DRB CASE ACTION LOG (FINAL PLAT)

DRB Application No.: 04DRB01136 (FP)

Project # 1001763

Project Name: ALBUQUERQUE WEST

PLAT OF
TRACTS C-1-A & C-1-B
ALBUQUERQUE WEST
SECTION 11, T. 10 N., R. 2 E., N.M.P.M.
CITY OF ALBUQUERQUE
BERNALILLO COUNTY, NEW MEXICO
JULY 2004

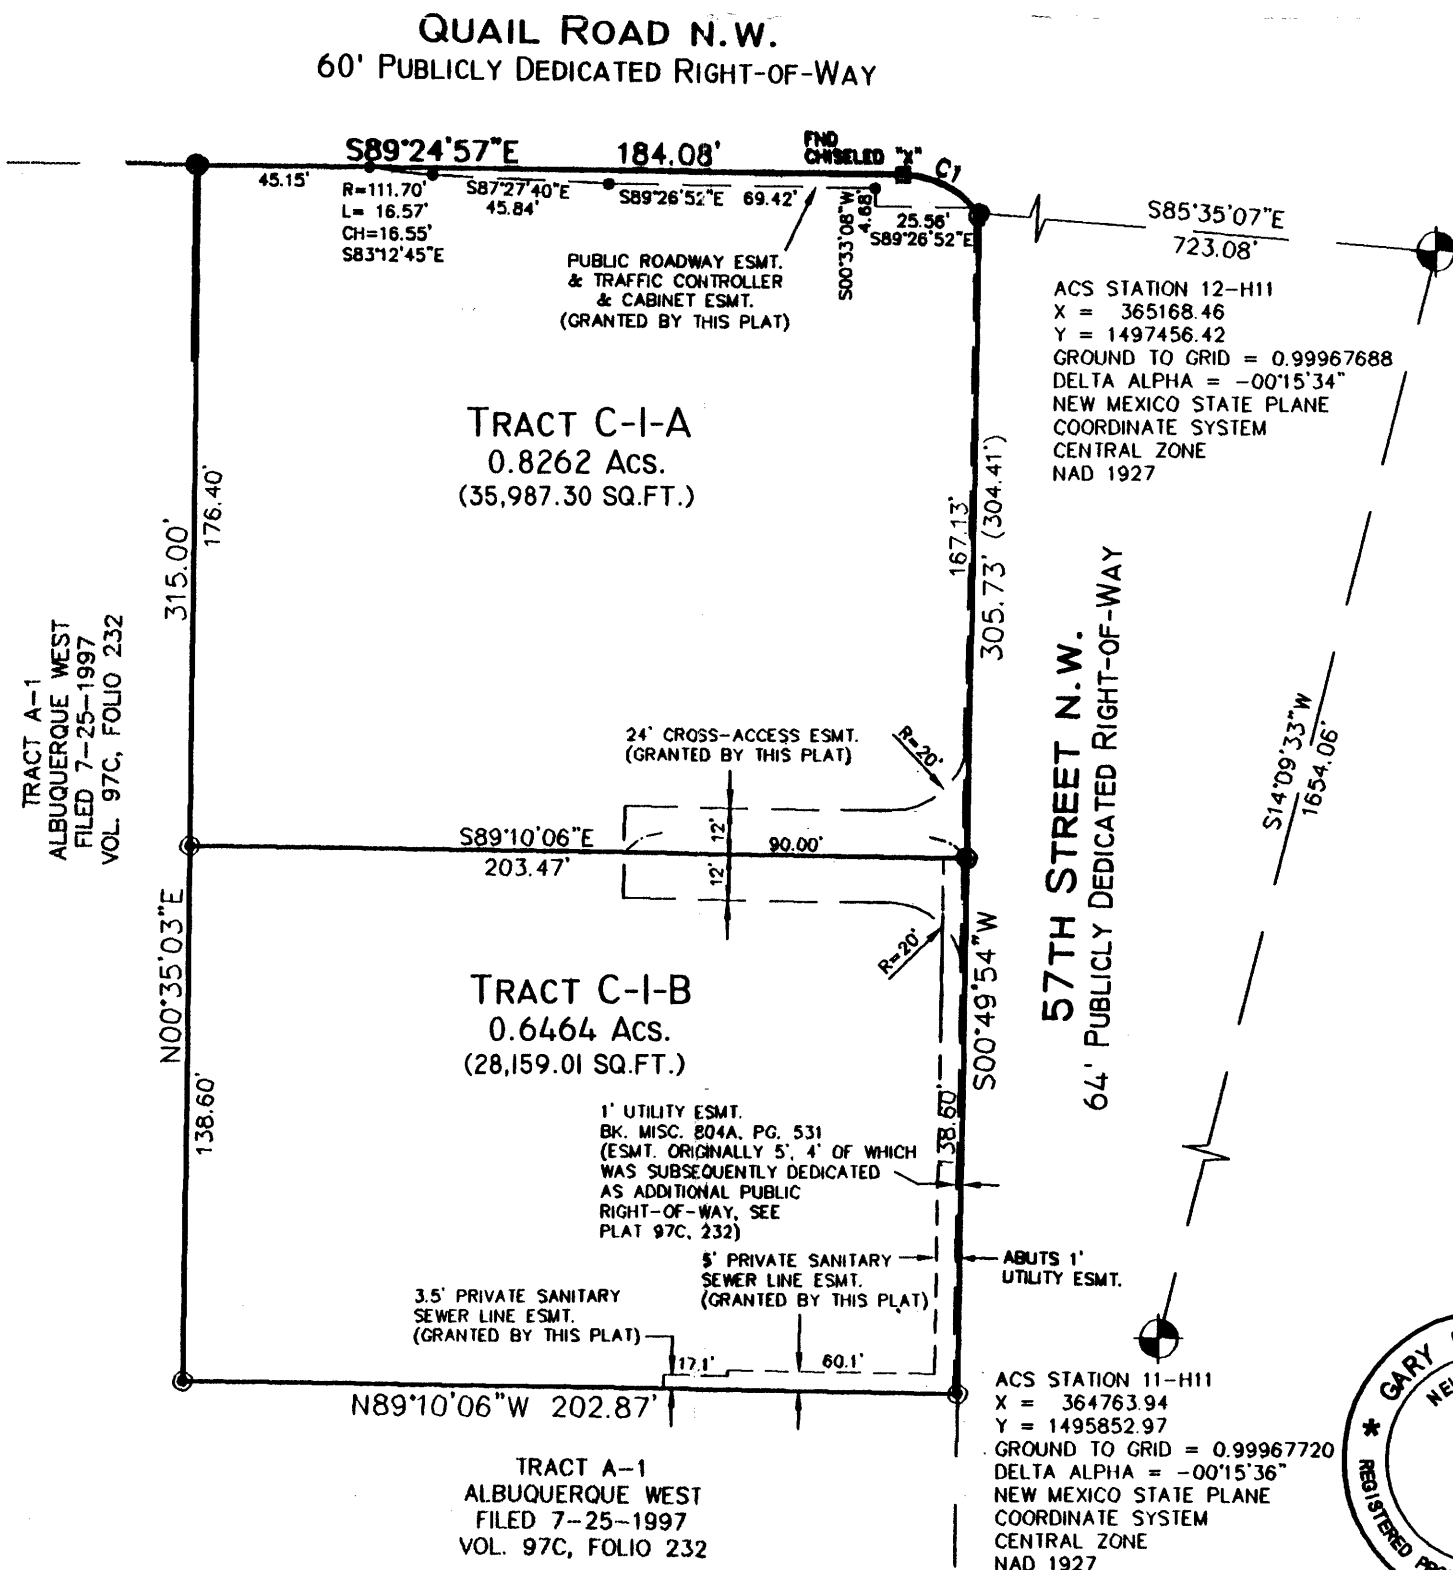
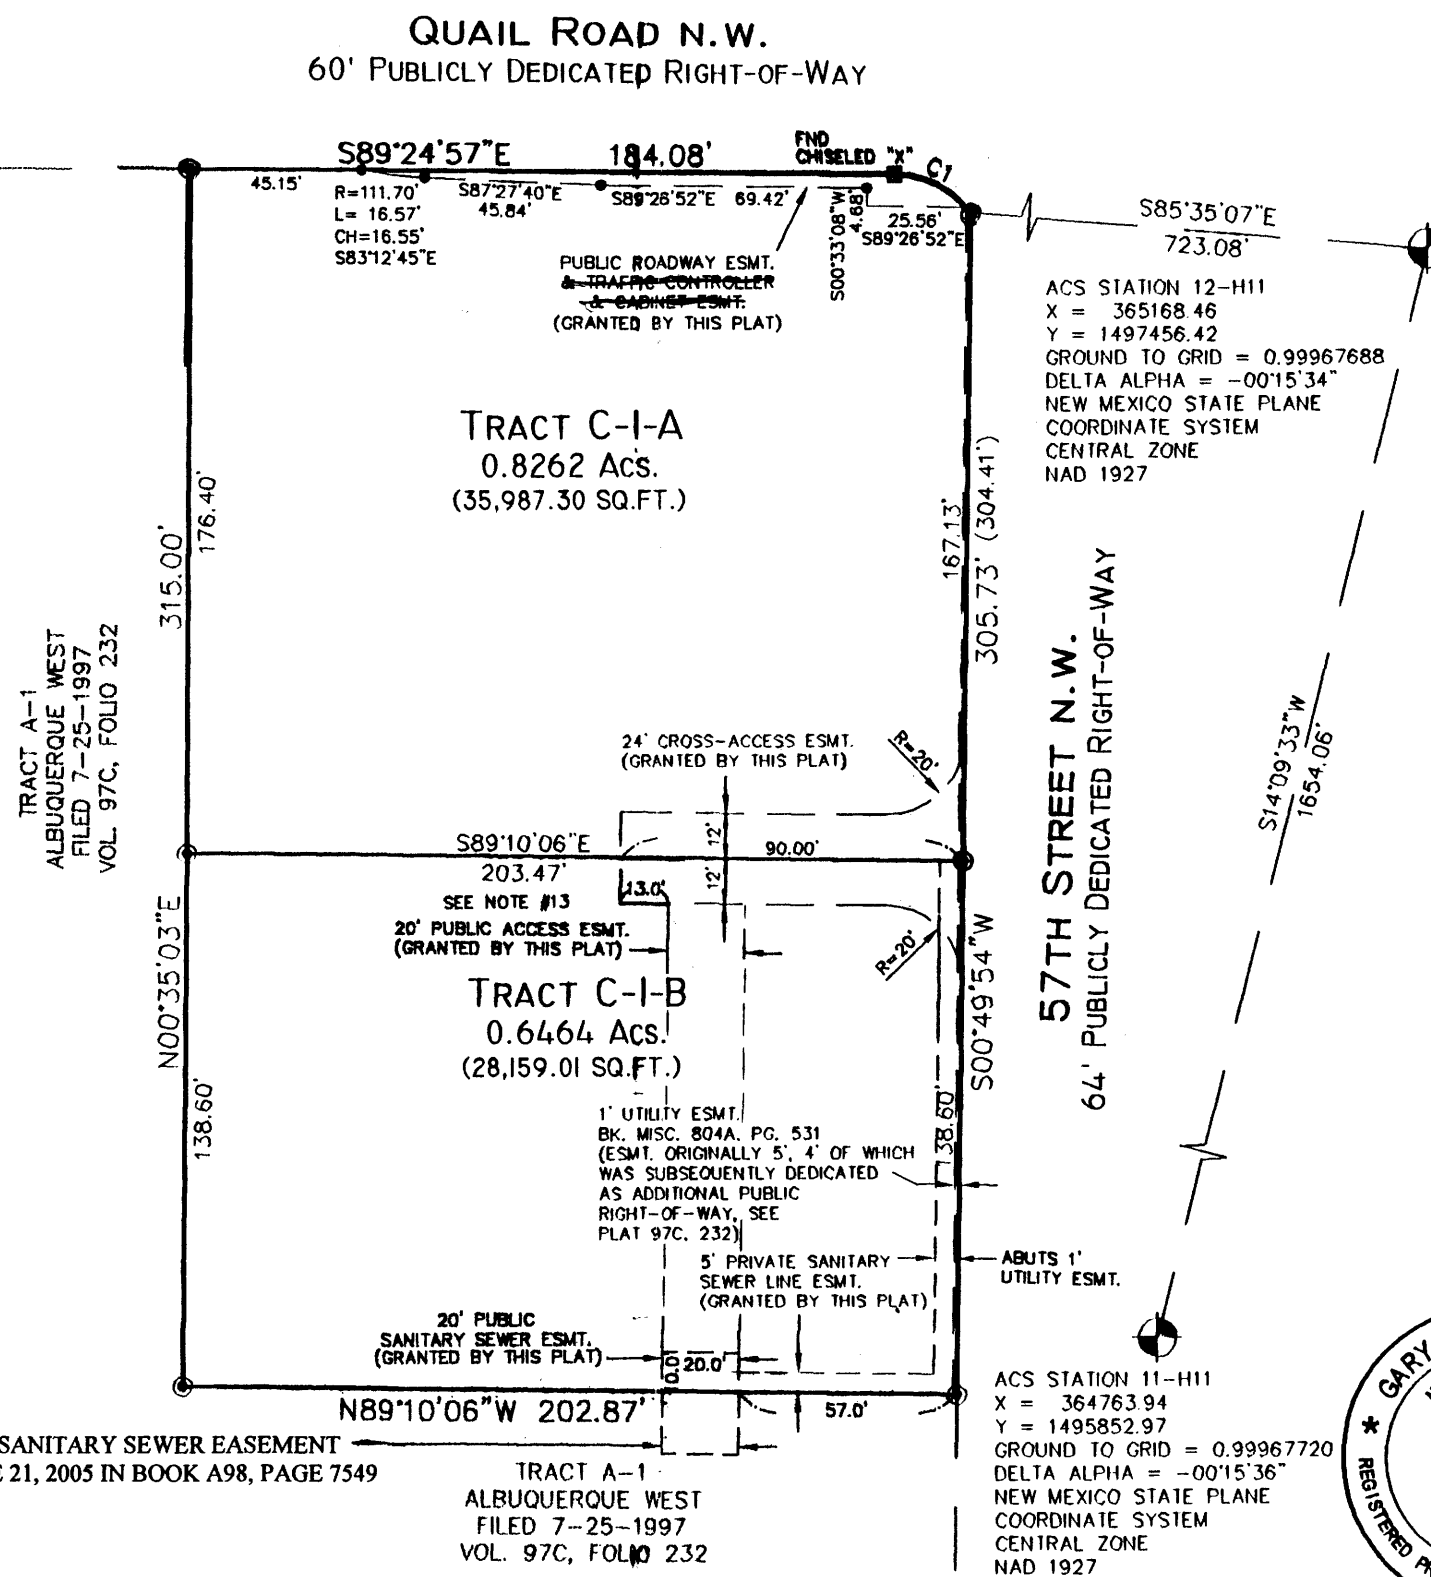
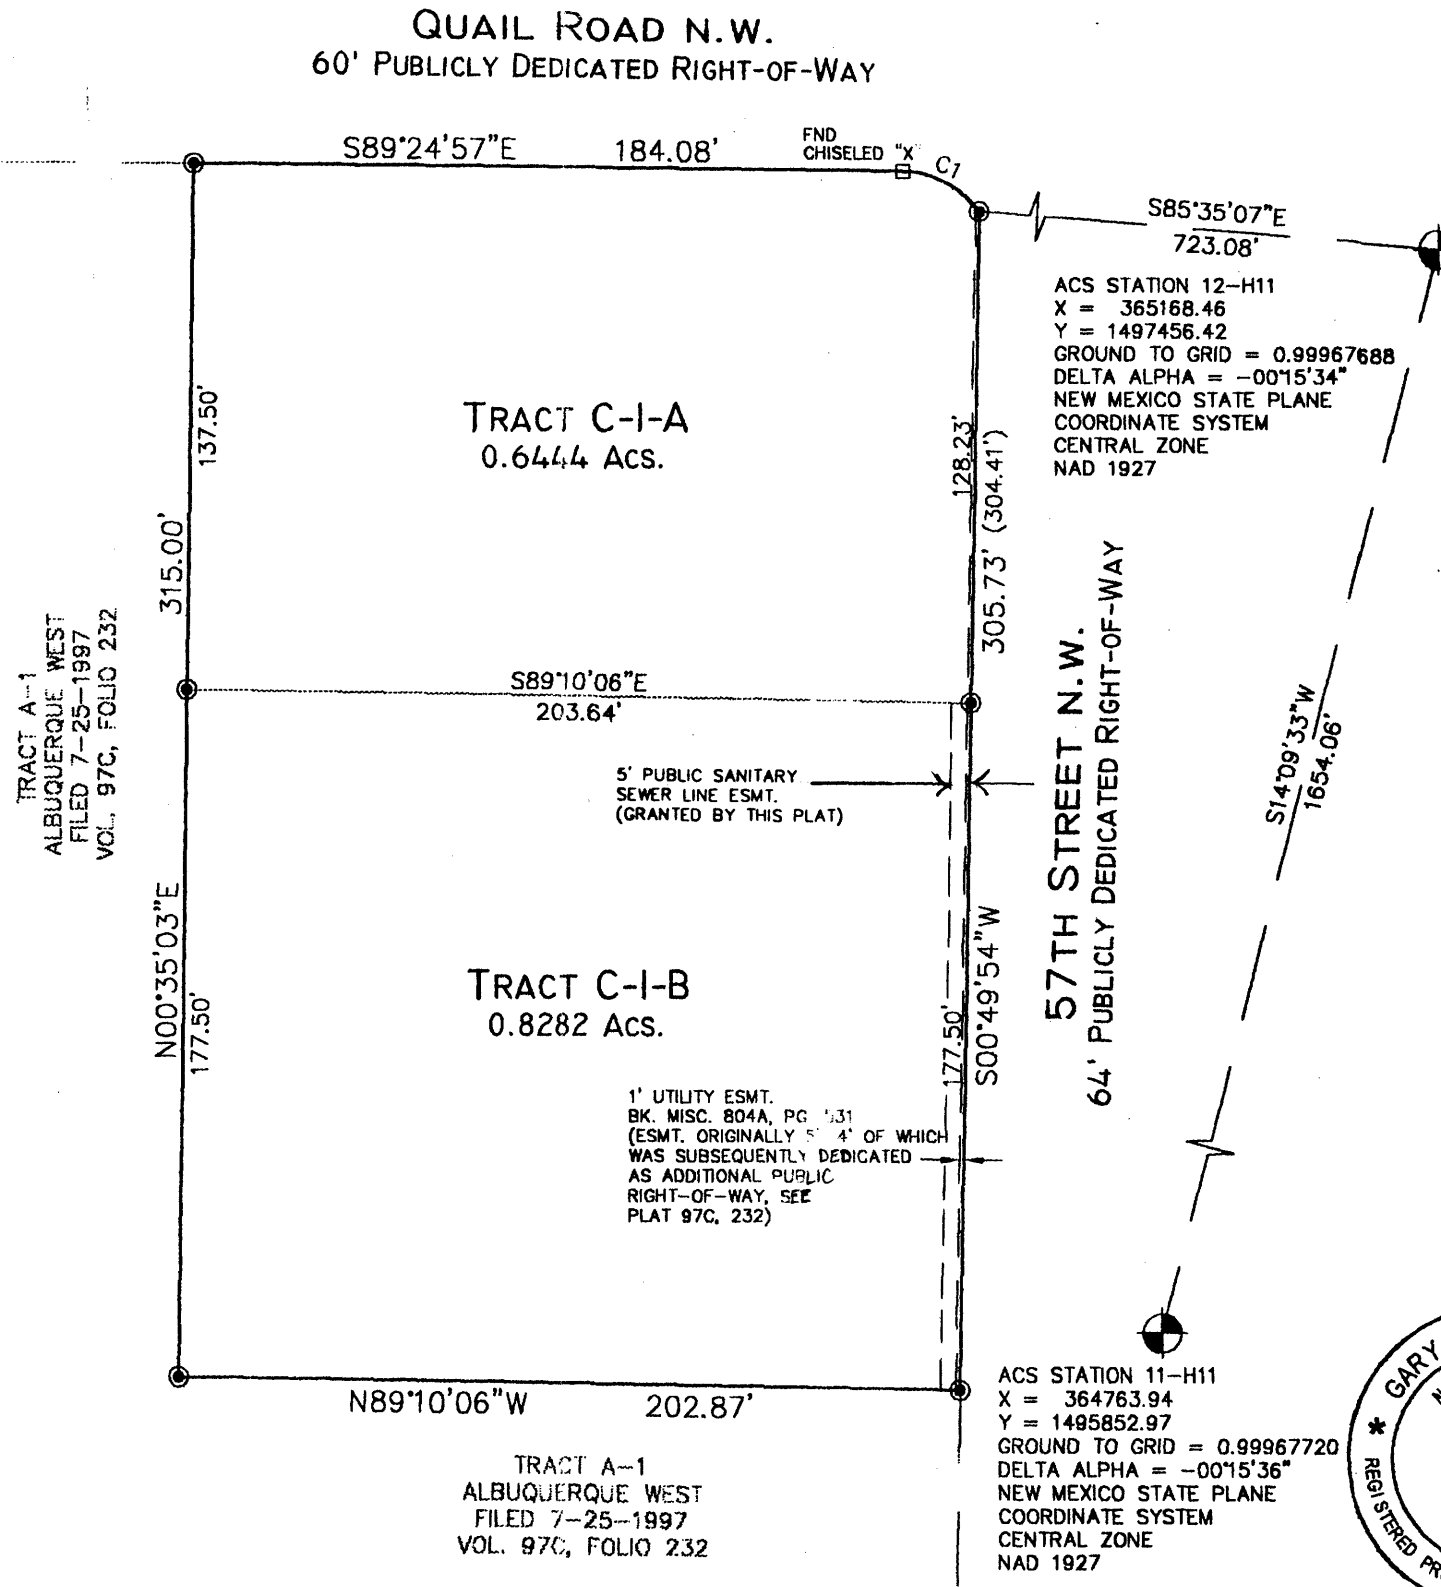
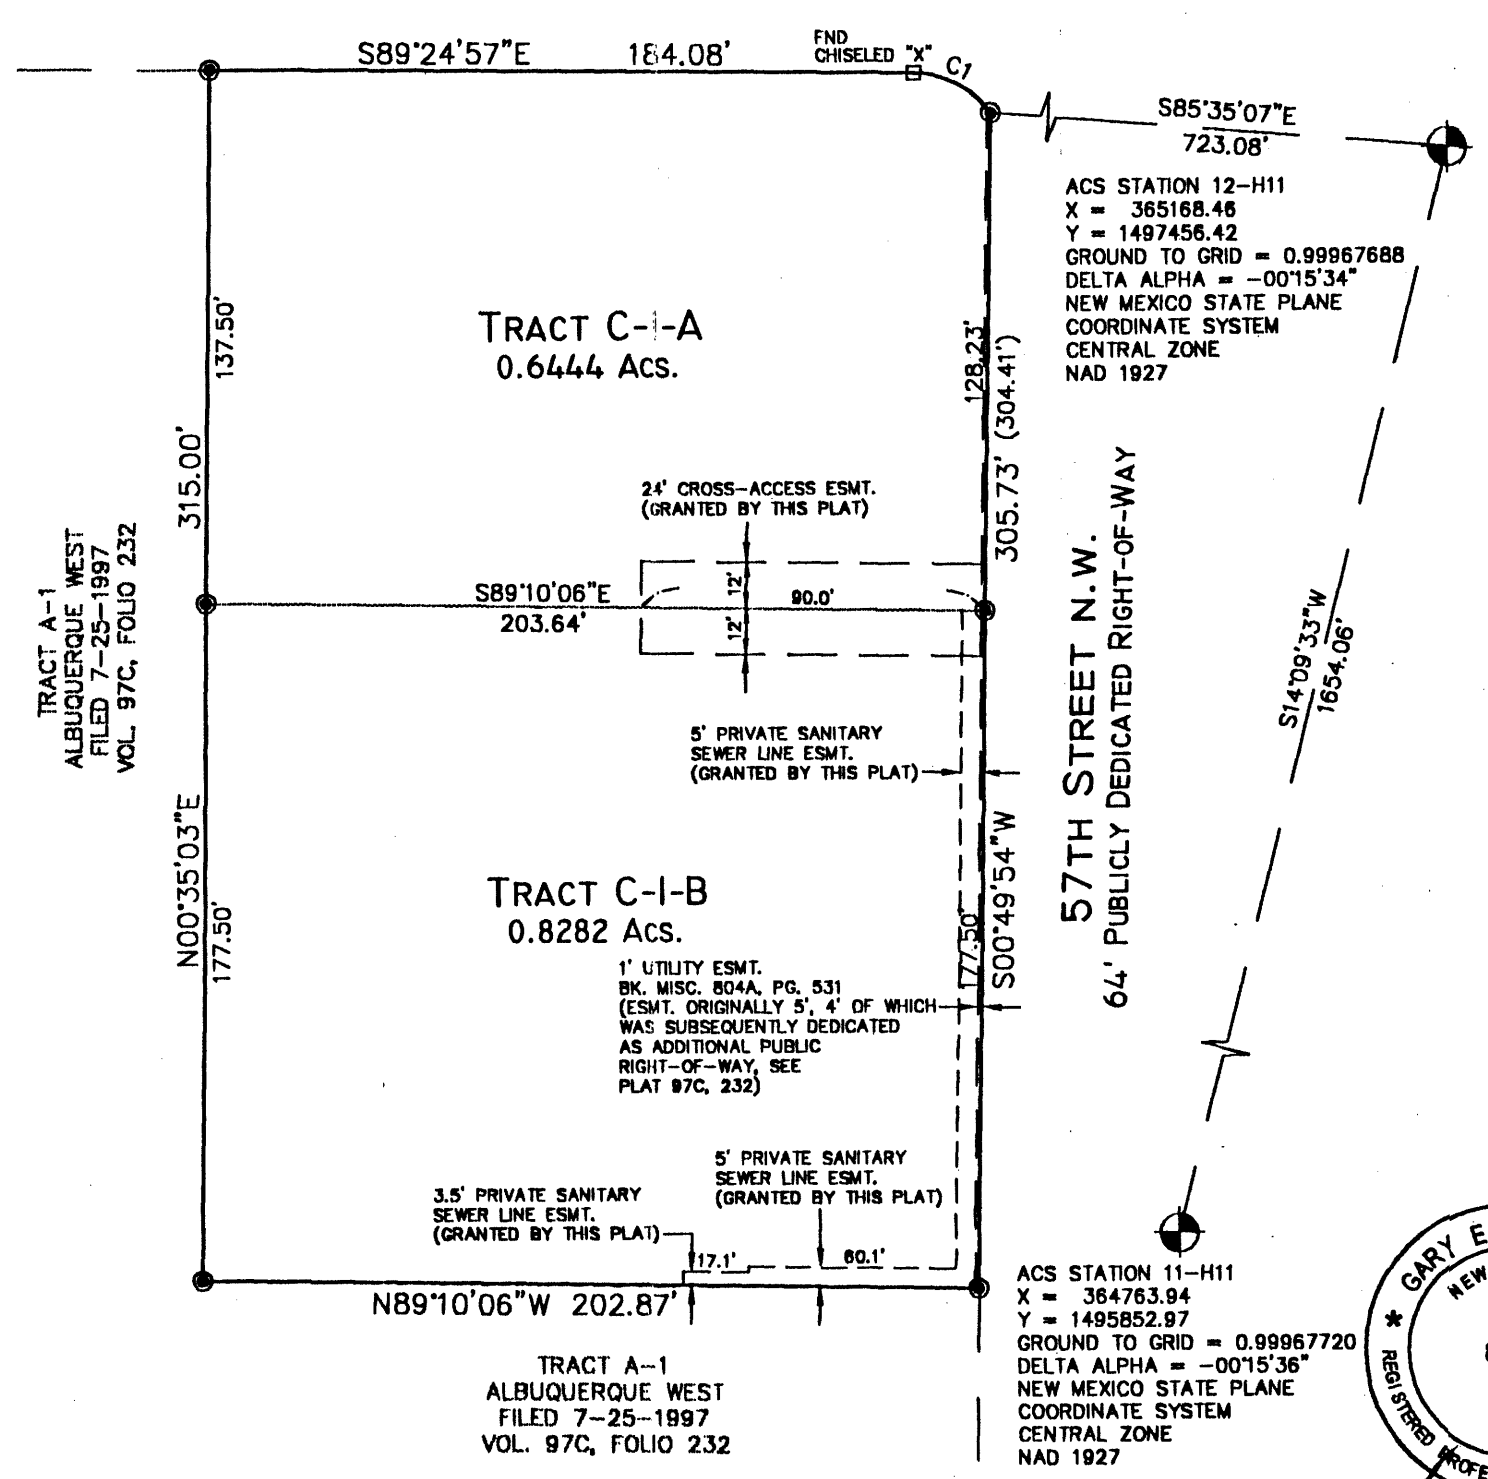
- UTILITIES: *Need off-site Sewer Easement recorded and information put on plat.*
- _____
- _____

- UTILITIES: Need off-site Sewer Easement recorded and information put on plat.
- _____
- _____
